Rezoning Transportation Analysis

Petition Number: 2020-140

General Location Identifier: Tax ID (06904142), Rozzelles Ferry Road & Zebulon Avenue

| Date | Description |
|----------|-------------------|
| 10-26-20 | First Review (EL) |

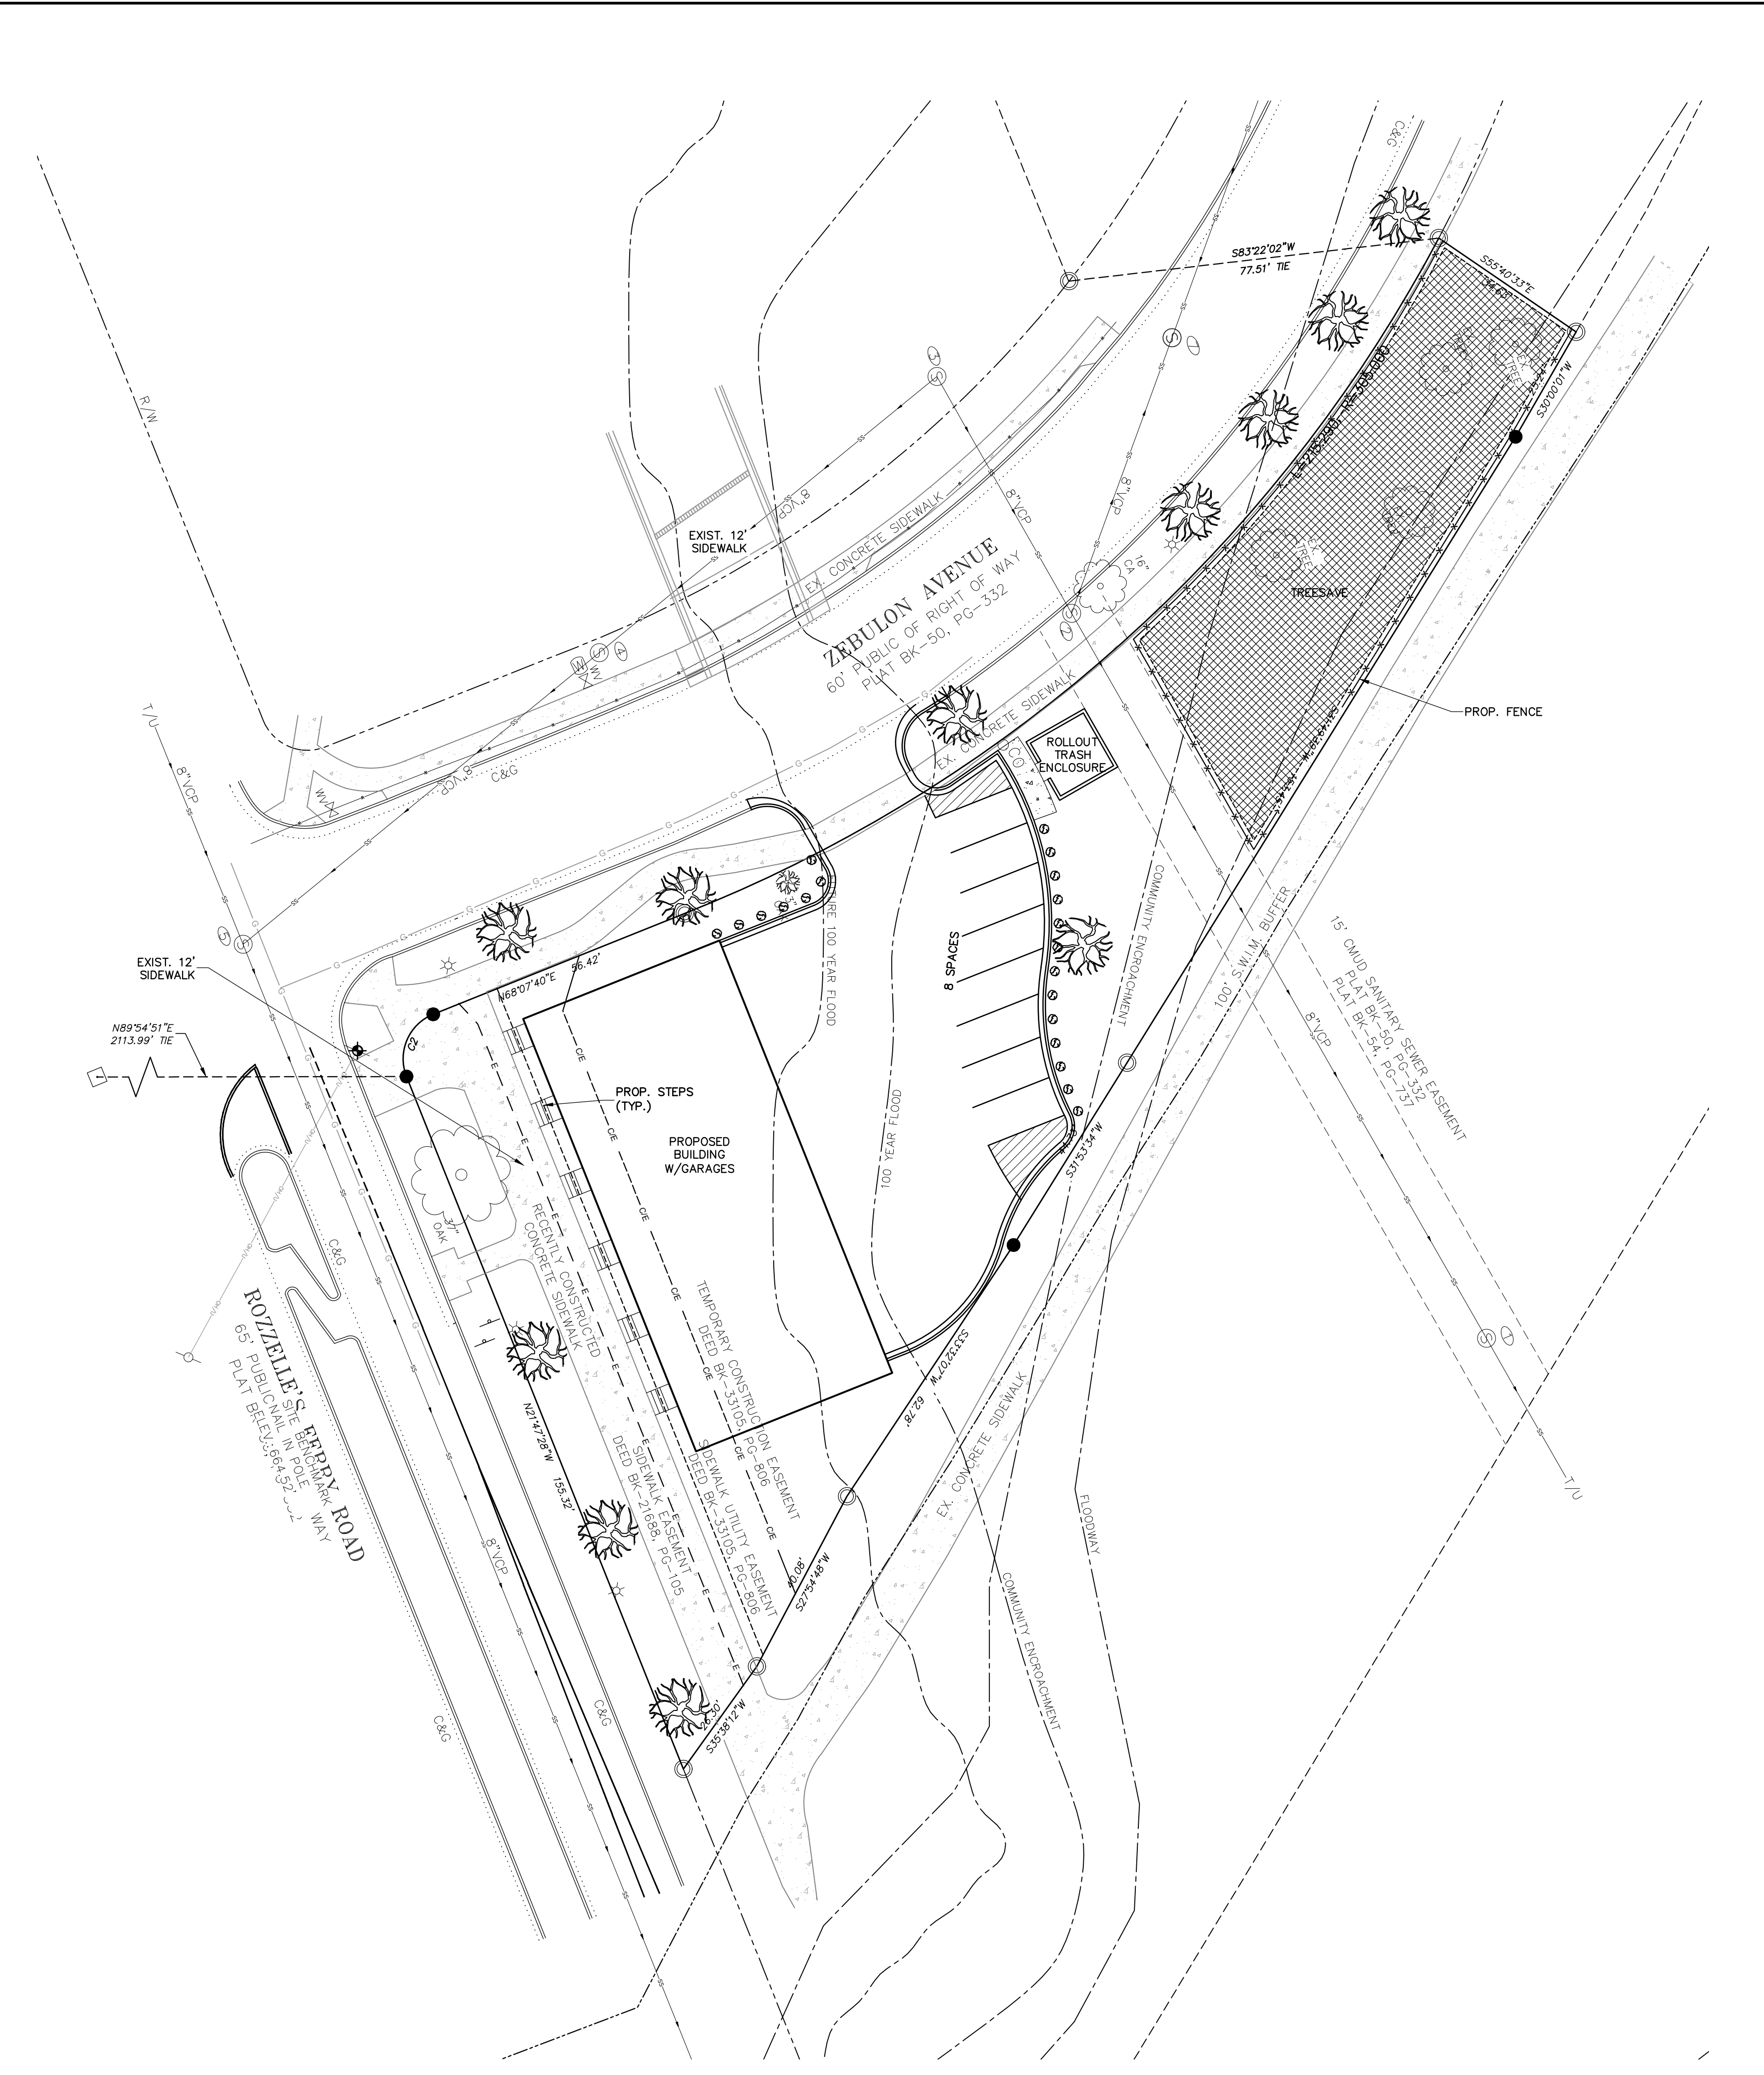
- Curblines:** The proposed zoning district has a setback measured from back of the existing or proposed future curblines.
 - Rozzelles Ferry Road:** The future location of curb and gutter is in its existing location.
 - Zebulon Avenue:** The future location of curb and gutter is in its existing location.

Label and dimension curb and gutter from the centerline for each road on the site plan.

- Add site plan note(s) specifying dedication and fee simple conveyance of all rights-of-way to the City before the site's first building certificate of occupancy is issued. CDOT requests rights-of-way set at 2' behind back of sidewalk where feasible.
- Add site plan note specifying that all transportation improvements will be approved and constructed before the site's first building certificate of occupancy is issued. The petitioner may phase transportation improvements if said improvements and phasing are explicitly described in site plan notes.
